**WEST SUSSEX COUNTY COUNCIL
STRATEGIC PLANNING CONSULTATION**

SUBJECT: FG/198/16/PL - Demolition of existing house with erection of 2 storey building comprising of 8No. residential 2 bedroom flats & associated external works (Revised site plans).

1, Sea Drive, Ferring, BN12 5HD

JOB: 1 SEA DRIVE, FERRING, WORTHING BN12 5HD
DWG: PROPOSED SITE PLAN

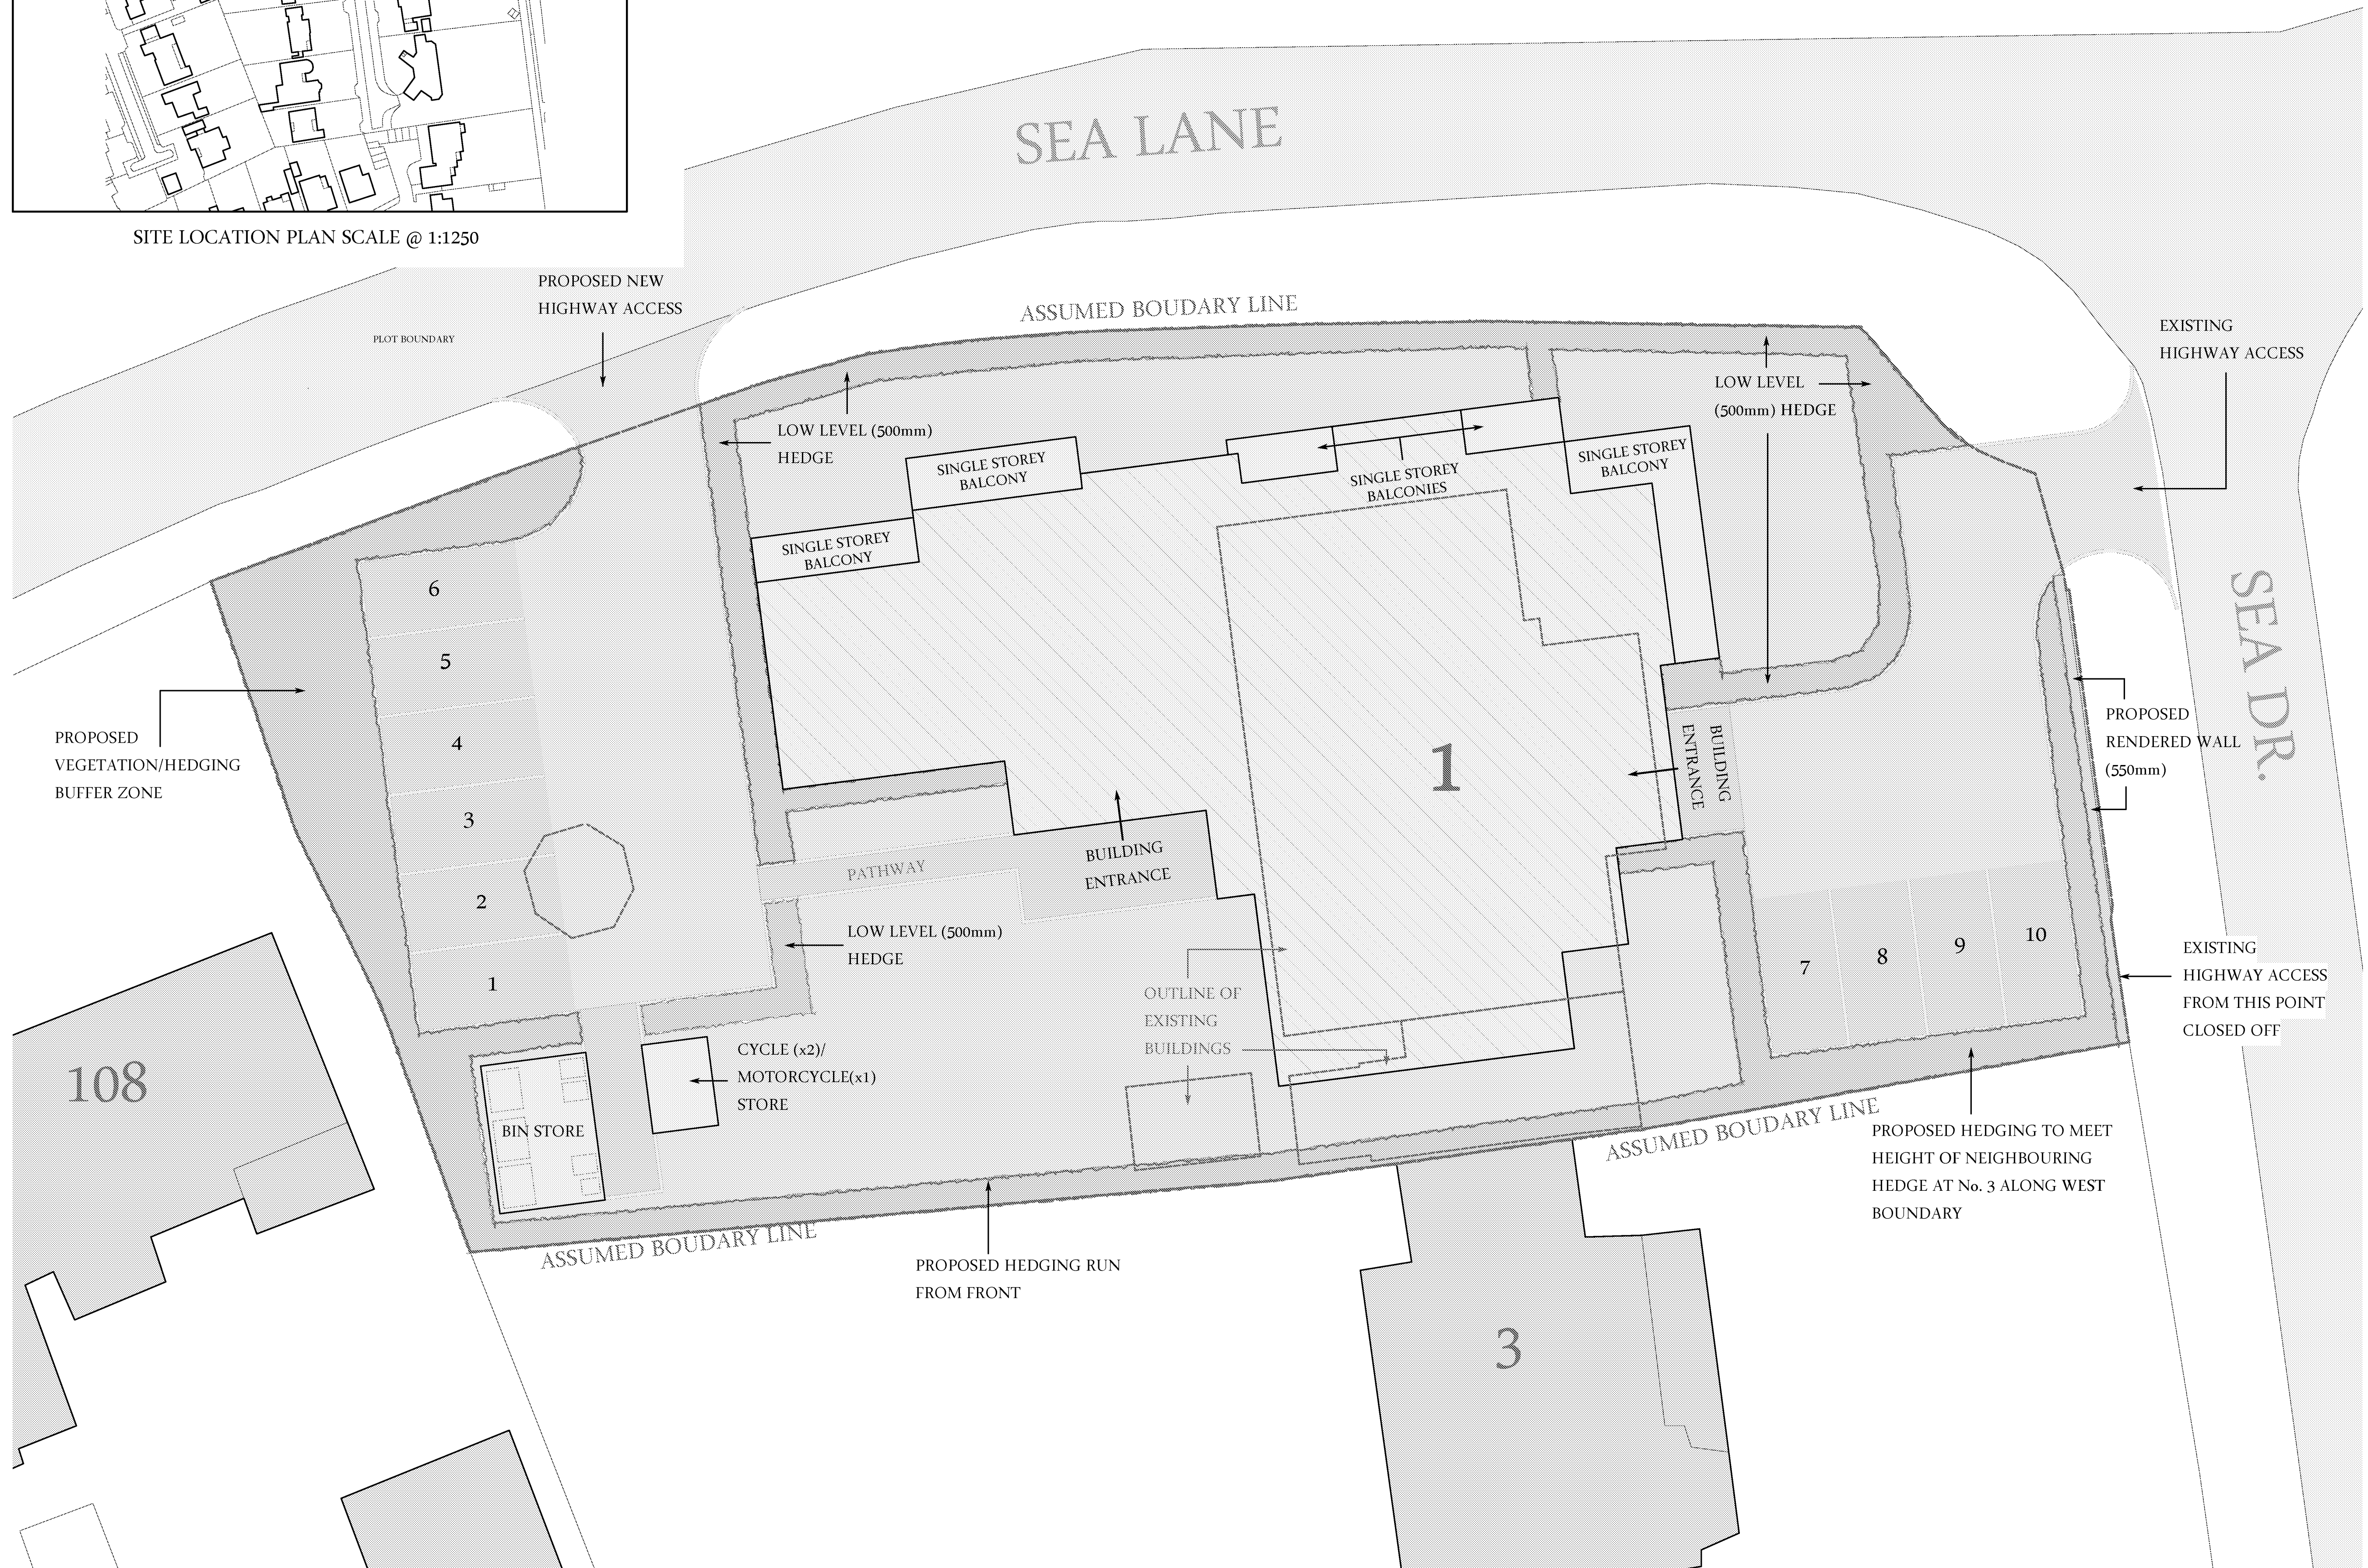
The LHA understand that the new access from Sea Lane has been removed from the scheme; with all access being taken from Sea Drive. An underground parking area is now proposed and two parking spaces located to the front of the development fronting onto Sea Drive, opposite the access to Bluewaters.

Parking is now proposed in an underground parking area with two parking bays fronting the site onto Sea Drive. These have been moved further away from the junction although they are still in close proximity and reversing into or out of these spaces whilst vehicles are entering or exiting the Sea Drive junction could cause a safety concern.

The access into the site and underground parking area appears to be 4m wide narrowing to 3m, this is not enough to allow two opposing vehicles to pass, shared access should normally be 4.5m, unless passing places are in situ; however given the frequency and low number of vehicular movements, whilst it made lead to inconvenience of users, it is not considered that this would lead to any impact on the highway.

The underground parking area appears tight, vehicle tracking should be provided to demonstrate this is workable. In particular there is no turning head, it may be difficult for vehicles to get into and out of bays 6 & 7 and should a vehicle enter and all spaces are taken then it would involve them reversing out up the ramp, this could cause an inconvenience for residents/visitors and traffic could back up onto Sea Drive. There also doesn't appear to be any provision for visitor parking or home delivery vehicles.

Whilst the LHA would not raise any highway safety concerns with this development the LHA would advise that the above points relating to parking/turning and passing are looked at by the applicant.
